WALBERTON PARISH COUNCIL

Ref :- WA/7/19/RES – minor amendments

Walberton Parish Council wishes to record an Objection to the above planning application, based on the following comments:

PJ DEVELOPMENTS LTD 2 Square Chambers 23 High Street Emsworth PO10 7AQ Tel: 0843 289 3430 Email: enquiries@pjdevelopmentsltd.com	
PROJECT: FORMER LANES END	
SITE PLAN OUTLINE PLANNING APPLICATION	
DATE: JANUARY 2019	DWG. NO 19-001 PL02
SCALE @ A1: 1:200	
REV: C

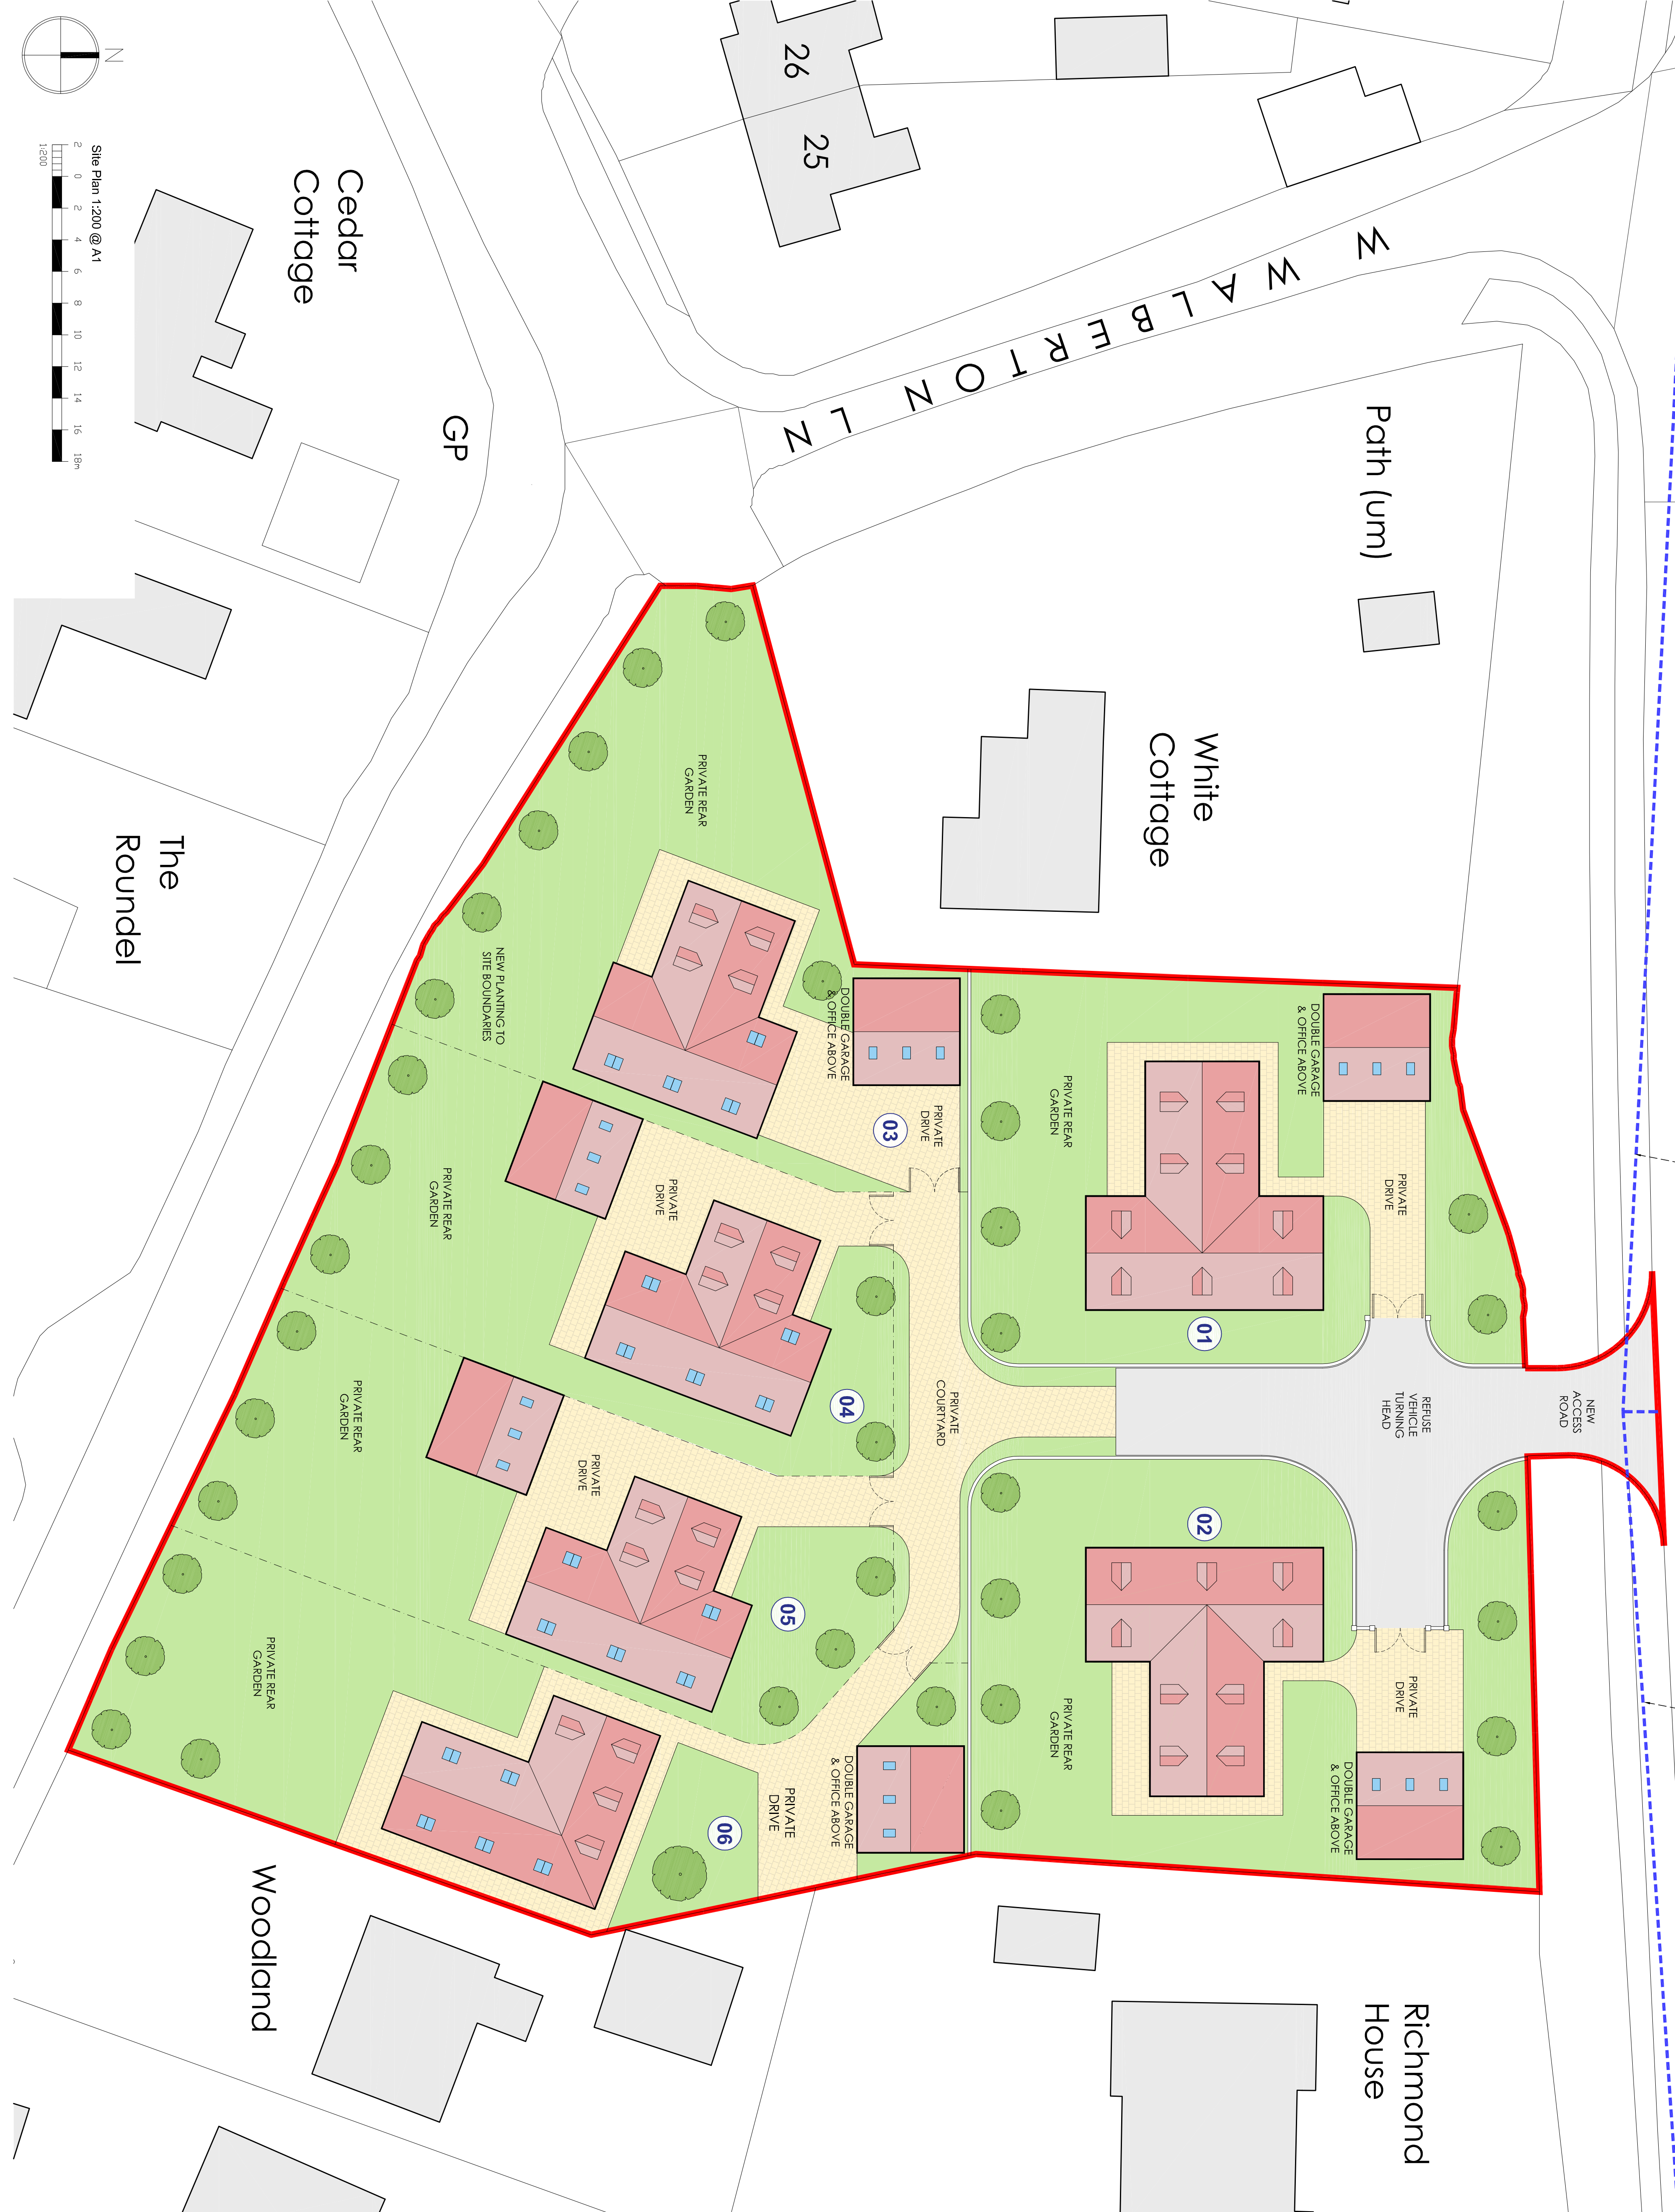
It is clear from the latest Application that the buildings within the Development have been moved further south and the original small boxes for Units 3 to 5 now have full height extensions. In WA/26/18/OUT the Applicant also said "It is proposed the development be a gated development with the entrance gates set back from Arundel road to allow cars to pull off the road when entering. Properties one and two would be served with a double garage each and additional parking for up to three cars. Properties three to six would be served by a single garage each with additional parking for further three cars per dwelling" However in West Sussex Consultation doc of 21 November posted on Portal 22 November reference is now made to 6 Detached Garages 2 of which are at the rear of Units 4 and 5.

In the previous Application WA/26/18 /OUT Unit 6 ran from the rear wall of the garage of the property called Woodland on West Walberton Lane to the rear of its Conservatory and in the latest it shows it running from the front of the garage to front of the House and beyond.
